Application No.	MP 08_0098 MOD 13
Location.	20-80 Pyrmont Street, Pyrmont
Proponent.	Star Entertainment Group Limited (hereafter SEGL)
Council Area.	City of Sydney
Approval Authority.	Minister for Planning or Independent Planning Commission under the Environmental Planning and Assessment Act 1979.

Submission of Objections with Grounds as follows: Noise impact, Air impact, Light impact, Security & Privacy impact

Figure 4 Proposed Connection to Authority Water Mains

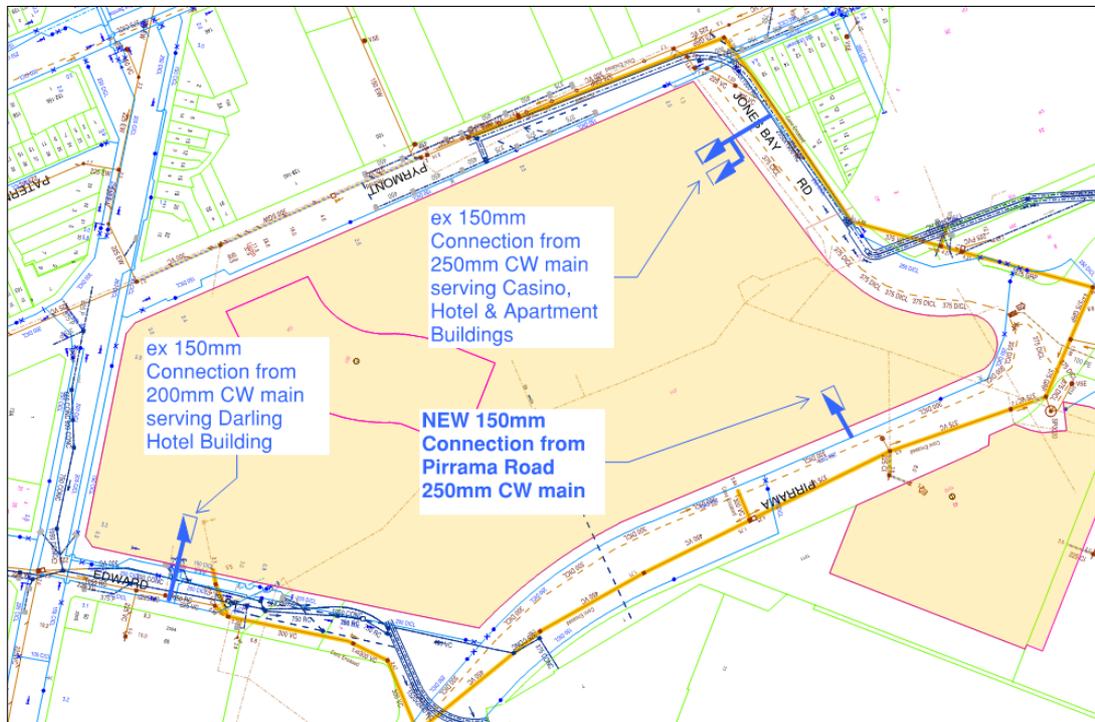
Details of the potential negative impact on existing trees (on public and private land) from Hydraulic infrastructure works on Jones Bay Road are absent from this development application. This development submission is missing details on how deep (horizontally and vertically down) are the mains and existing mains connection points beneath the rear of 14, 16 & 18 Pyrmont Street terrace homes as the existing connectors to authority water mains and the proponents water supply in Jones Bay Road runs beneath our properties. If the existing peak demand for the water main connection Jones Bay Road is to increase, works will need to be done to increase the size/ flow to the applicant's site. Any impact on the Jones Bay Road trees and private trees will further expose the 3 remaining heritage terraces to hundreds of occupied SEGL spaces with windows. Allowing for people to see what we do in our homes and when. Plus frighteningly, people will be able to see when we are asleep or not home. (Increasing Privacy / Security Risk concurrently with increase numbers of people). Service interruptions and impaired communications services (TV antenna reception) will occur as a direct result of the scale of the build next door to us.
